Landscaping: (to include transplanted trees)

DETAIL MAP 1 - Landscape Plan

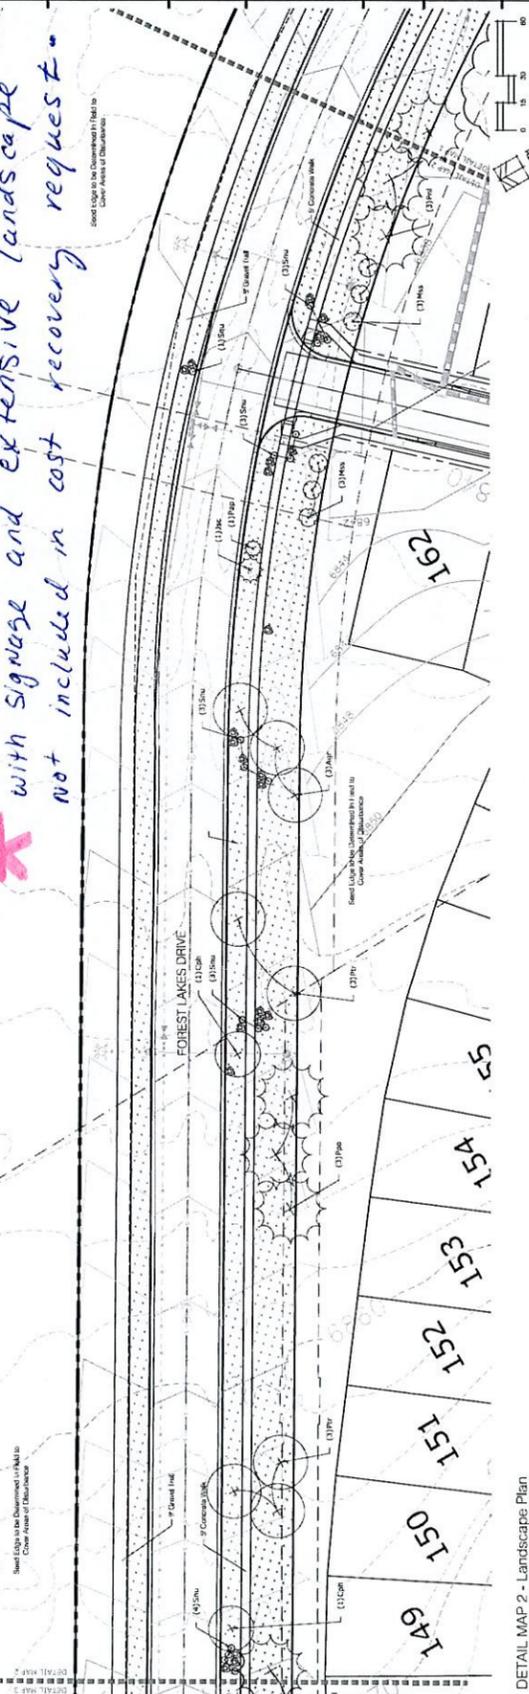
The estimate from Bear claw was not signed and the numbers do not match the value of \$70,866.25 being 21% (where the estimate shows \$471,193.00). Please provide the actual finalized scope of work (preferably for the exact work in the exact location for this request). It is also not clear where this work is located. It appears as if it is the street scape for Forest Lakes Drive.

The Bear Claw, All American and the Kempton invoices/estimates all have irrigation. Please supply a justification as to why you would use all of these for your baseline when the All American estimate dated 1/5/16 clearly calls out Forest Lakes Drive.

Response: We were told at the initial meeting that we could supply *either* estimates or invoices. We tried to provide both for your convenience. Since we have provided invoices are we now required to provide proposals with signatures? The invoice from Bearclaw that was charged to this filing indicates that they are about 21% complete. This note on the invoice is their estimate, not ours. The invoice should have been about \$99,000 if it truly reflected 21% of the Proposal amount. The proposal from Bearclaw only covered a portion of the area that we are claiming on the cost recovery. All American had several proposals that also covered parts of the area that we are requesting in the cost recovery. That is why we included all proposals along with a plat indicating the tracts associated with the proposals. The proposed recovery area was landscaped in part with Fil.1, part with Fil. 2A and part with 2B. As several different landscapes and proposals covered the area for the cost recovery, we felt the best way to get a fair estimation of our cost for the area in question was to add all of the costs and divide by the square footage requested in the cost recovery. We feel that \$1.87 per square foot is a fair estimate as we are now looking at \$2.80 per square foot on many of other projects. The estimate dated 1/5/16 from All American was a proposal that we did not accept and therefore should not have been included in this paperwork and has nothing to do with the cost per square foot. Sorry about the mix-up. I have included the landscape plan along with the estimates and invoices. This streetscape plan highlights the recovery area on Detail map 1, 2, 3 and 4. Again, this did not cover the entire proposed recovery area.

## Forest Lakes Dr. Cost Recovery Exhibit

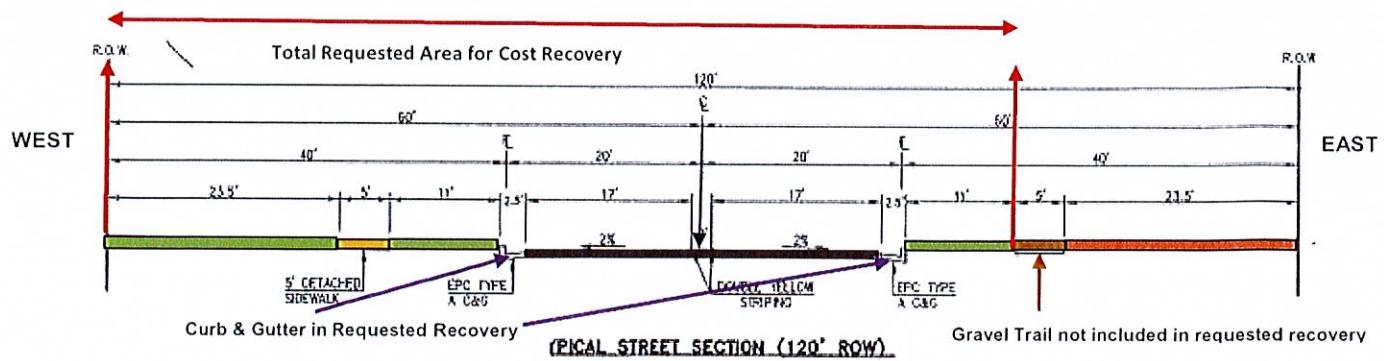
Please take note of the highlighted area on the spread sheet. The total lineal foot of C&G requested is not consistent with the take offs for this section of road. Please clarify why your request is higher than the quantity take offs, or adjust the number to reflect the correct amount. Please confirm, under c&g prep, your reference of PPC invoice 1521-9 (highlighted on spread sheet and called out as document page 80). I do believe this was intended as invoice 1521-8. Please justify this cost. Please check both blue highlighted invoices.

Please take note of the highlighted area on the spread sheet. The total square foot of stamped concrete requested is not consistent with the take offs for this section of road. Please clarify why your request is higher than the quantity take offs, or adjust the number to reflect the correct amount.

Please verify the take-off quantities vs the amount of concrete requested for both C&G and sidewalk. It appears as if you are requesting more concrete than the project required. Please justify the amount in this request or revise to match the amount calculated per take-offs from the plans.

Response: C&G: approx. 6620 LF Concrete for Curb & Gutter (Approx. 380 yards X 12% waste=425 cubic yards)

We have adjusted our numbers to reflect the linear footage and cubic yards of concrete indicated above. You are correct the invoice 1521-9 was intended to be 1521-8. This amount is for skid steer prep work on the curb and gutter.

Response: Stamped: approx. 1418 SF Concrete for stamped in recovery area: 17.5 cubic yards

Response: We have revised the quantities versus the amount of concrete for both C & G, stamped concrete and sidewalk to reflect the correct takeoff for the recovery area.
